Appeal Decision

Appeal Ref: APP/R5510/D/23/3322088

15 Roker Park Avenue, Ickenham, Hillingdon UB10 8ED

- The appeal is made under section 78 of the Town and Country Planning Act 1990 against a refusal to grant planning permission.
- The appeal is made by Mrs Ru Cheema against the decision of the Council of the London Borough of Hillingdon.
- The application Ref 41735/APP/2023/140, dated 17 January 2023, was refused by notice dated 8 March 2023.
- The development proposed is described as a first floor side extension to enlarge the current room in support of a larger family home.

Proposed first floor

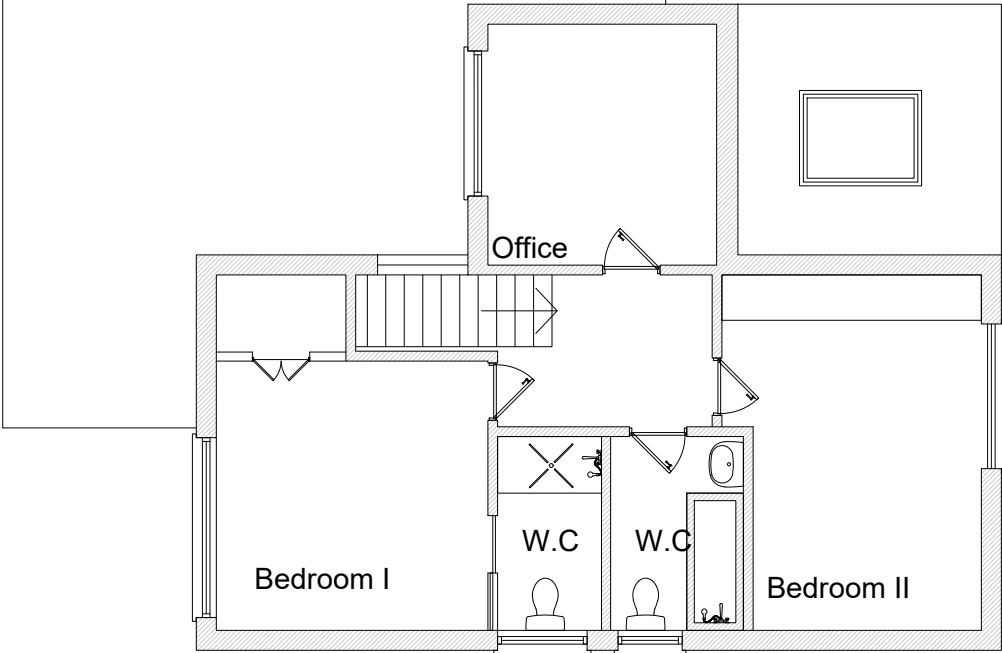
5. The proposed extension would be sited above the host's integral garage, where its distinctive vertical side window is located, and would be set back around 0.5 metre from the building's front face. Consequently, although the extension would have the same ridgeline as the host, the original building's staggered form, which is so typical of Roker Park Avenue, would be much diminished. In the streetscene, the resultant building would thus be markedly at odds with the prevailing style of houses in the road.
